Site Location/Project: 90-102 Regent Street, Redfern, NSW

Our Ref: 210430_90-102 Regent St_Ad

Addendum to Arboricultural Impact Assessment Report (AIA) dated 29 September 2020

This document has been prepared to provide supplementary comments to the report prepared for the site, dated 29 September 2020, in response to comments raised by the City of Sydney Council.

GROUND LEVEL | PUBLIC DOMAIN LANDSCAPE PLAN

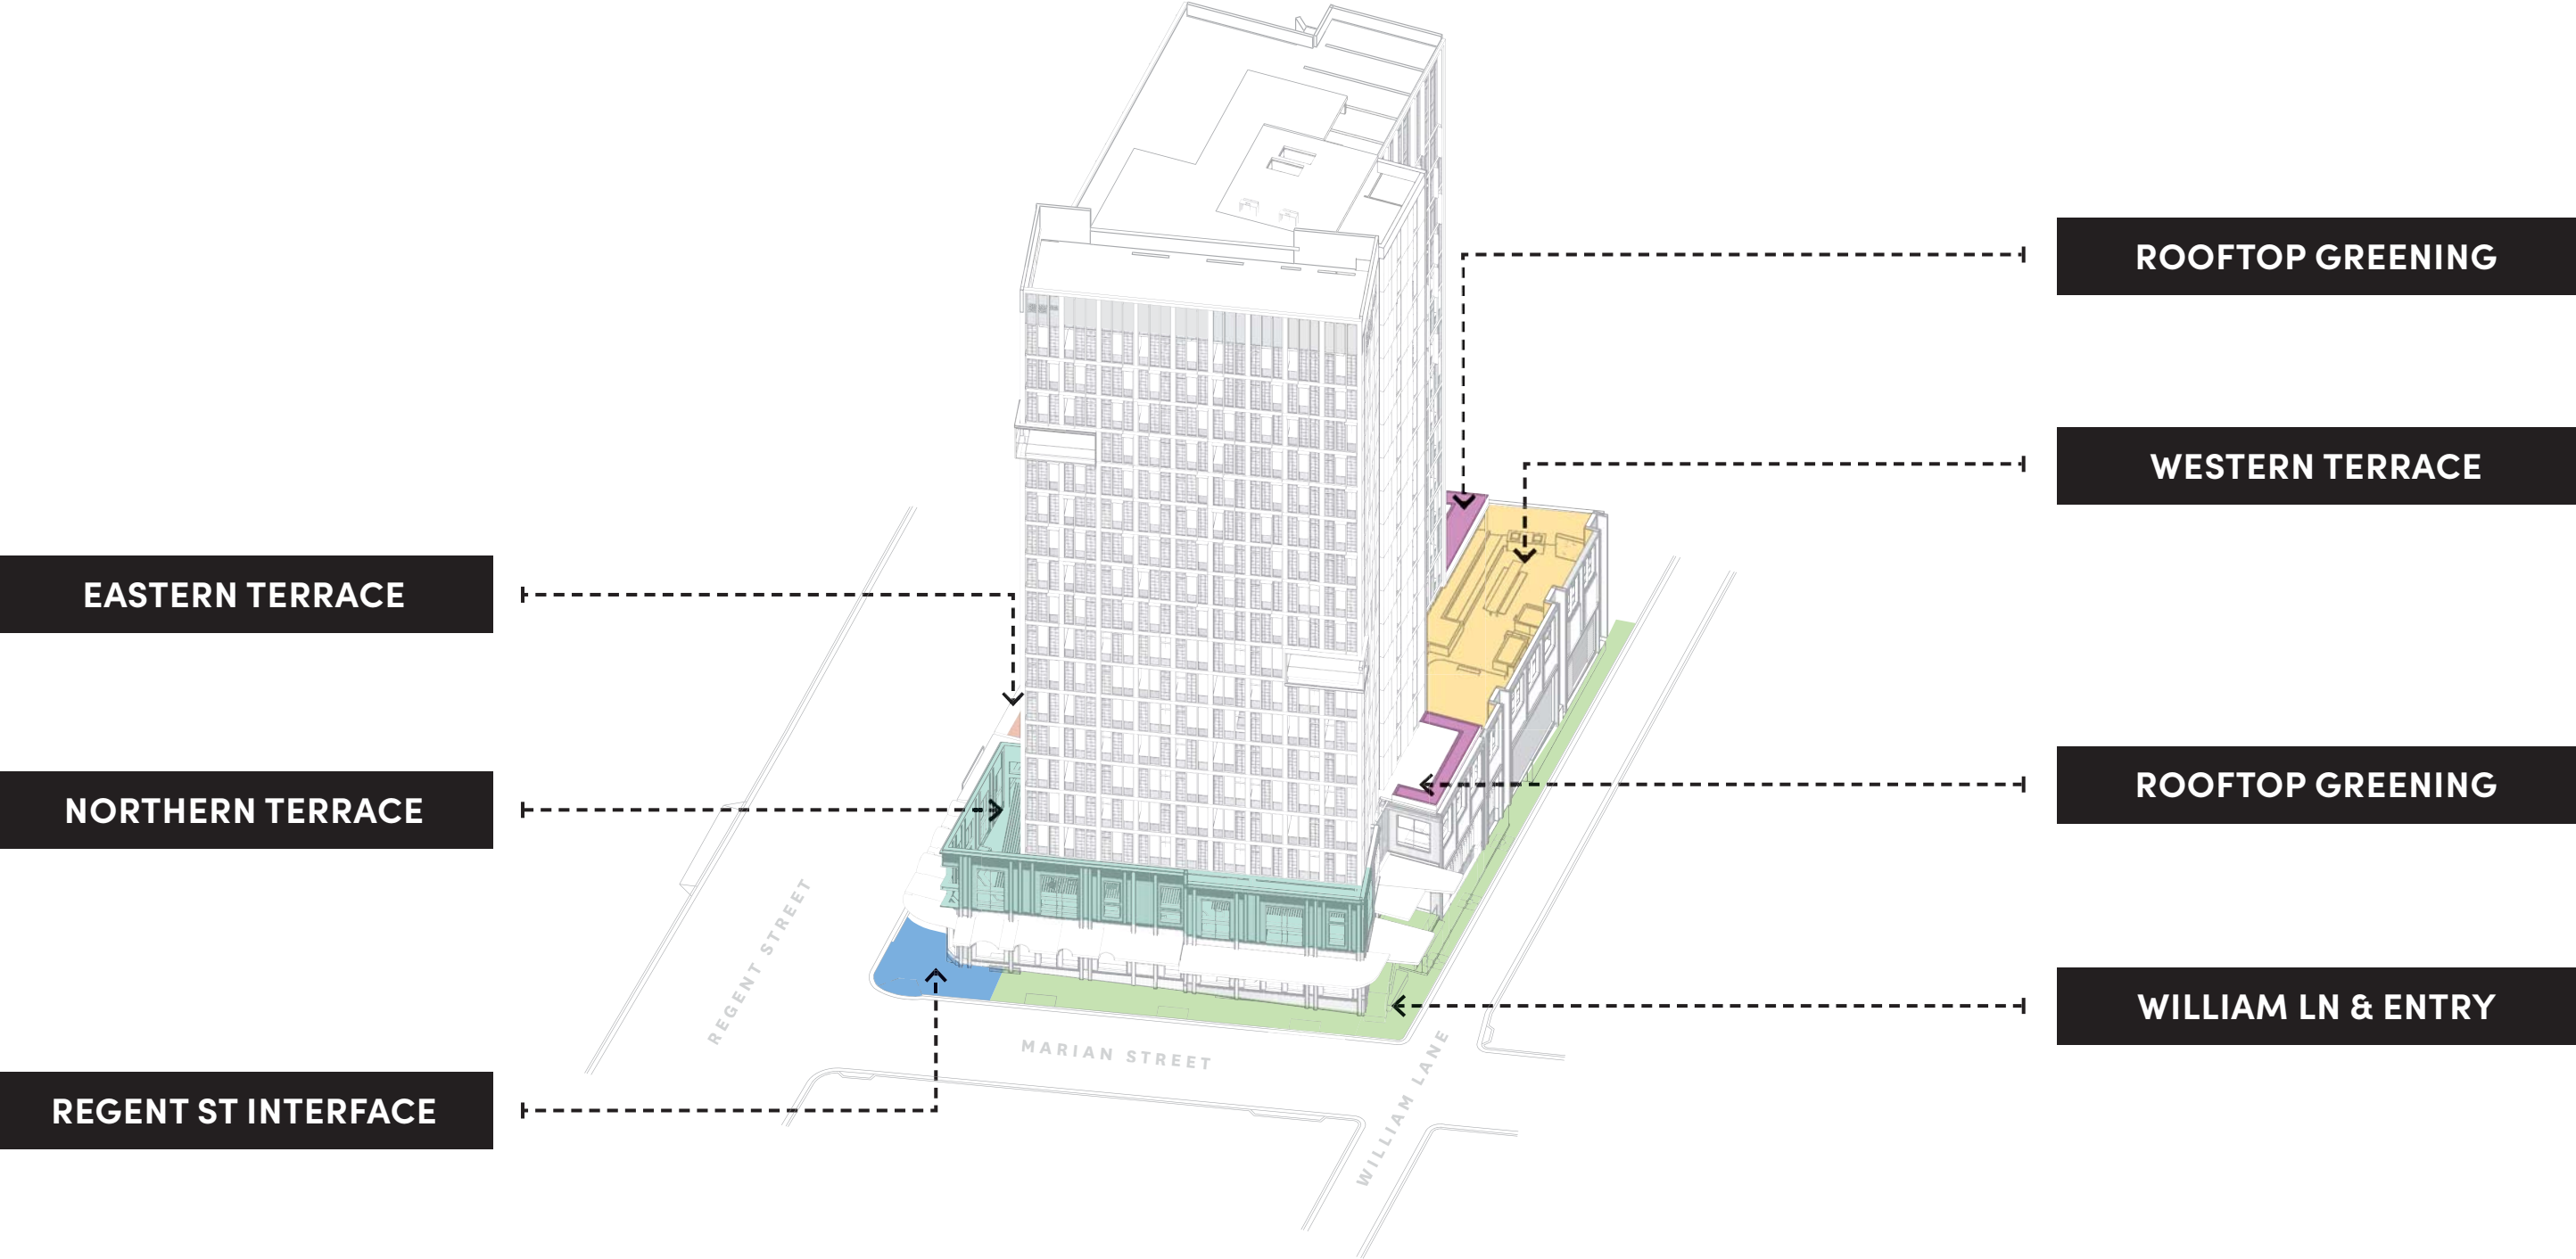
Item 2: Awning is too high to provide effective weather protection from rain, sun and wind and should be simple box awning without cut outs for street trees to both Regent and Marian Streets and consistent with the requirements of Section 3.2.4 - Footpath Awnings of Sydney DCP 2012. Any signage is to be within the fascia of the awning.

Item 16: Design elements including awnings, street furniture, footpath upgrade within public domain must ensure appropriate setbacks are provided from existing street trees to allow maturity of the trees to be achieved.

Item 20: Awning design must be amended to provide adequate space and clearance for new street trees to grow without conflicting with the awning.

The public domain works at Regent Street, in the Tree Protection Zone (TPZ) of tree 1, include the removal of the existing surface and replacement with concrete unit paving.

The public domain works at Miriam Street, in the TPZ of tree 2 and 3, include the removal of the existing surface and replacement with in-situ concrete paving. To minimise the impact to tree 1, 2, and 3, the construction of the new concrete paving on both streets must be carried out in accordance with Part D - Technical Guidelines of the City of Sydney Street Tree Masterplan 2011. All demolition and construction works must be carried out in accordance with AS4970 Protection of trees on development sites (2009), see section 11 of the AIA report for more information. Providing that the public domain upgrade works are carried out in accordance with these specifications, the trees will not be impacted development works.

The awning height has been lowered to between 3.2m-4.2m to allow for the slope of Regent Street. The awning depth along Regent Street has been reduced from 2.8m to 2m.

Tree 1 is the only existing street tree at Regent Street adjacent to this awning, which is a Plane Tree (*Platanus x acerifolia*) that is semi-mature in age class. Three new street trees are also proposed adjacent to the Regent Street awning. Canopy pruning for tree 1 will be required to accommodate the awning, the pruning will be required as per the specifications in section 9.2 of the AIA report. The pruning will not adversely impact the condition or amenity value of the tree and is therefore considered minor and acceptable.

Tree 1 is a Plane Tree (*Platanus x acerifolia*), the three new trees proposed at Regent Street are the same species, which is in accordance with City of Sydney Street Tree Masterplan 2011 of this section of Regent Street. The City of Sydney Street Tree Masterplan 2011 identifies that Plane Trees have an estimated mature height of 18-25m. The proposed height of the awning at Regent Street varies from 3.2-4.2m in height.

All three of the new trees at Regent Street can be formatively pruned in accordance with AS4373 Pruning of amenity trees (2007) to crown lift/modify the shape of the crown to remove/reduce lower branches below a height 3.2-4.2m (the height of the awning) to prevent branches conflicting with the awning in the future.
